Arun District Conservation Area Advisory Panel
c/o Civic Centre

Application No: AB/40/20/HH

Site Address: Mews House London Road Arundel BN18 9BH

Description of works: Single story rear extension with roof terrace extending across to existing terrace, shiplap panelled ground floor wall, addition of rendering, alterations to fenestration & new brick garden wall. This application may affect the character & appearance of the Arundel Conservation Area.

**Existing North elevation
scale 1:100**

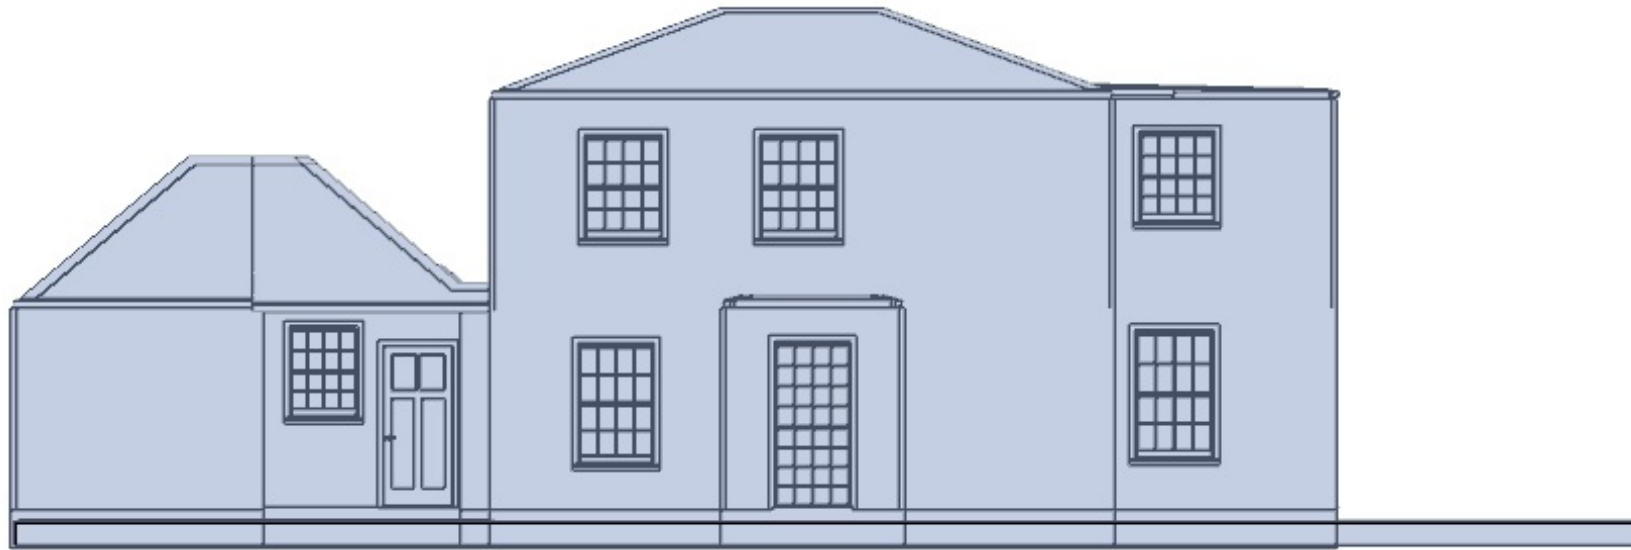
The replacement of the relatively small area of shiplap with suitably coloured render on the street elevation will have no adverse impact on the character or appearance of the conservation area. Neither too will the construction of the garden wall as long as the bricks, mortar and bonding match those on the side elevation of the house.
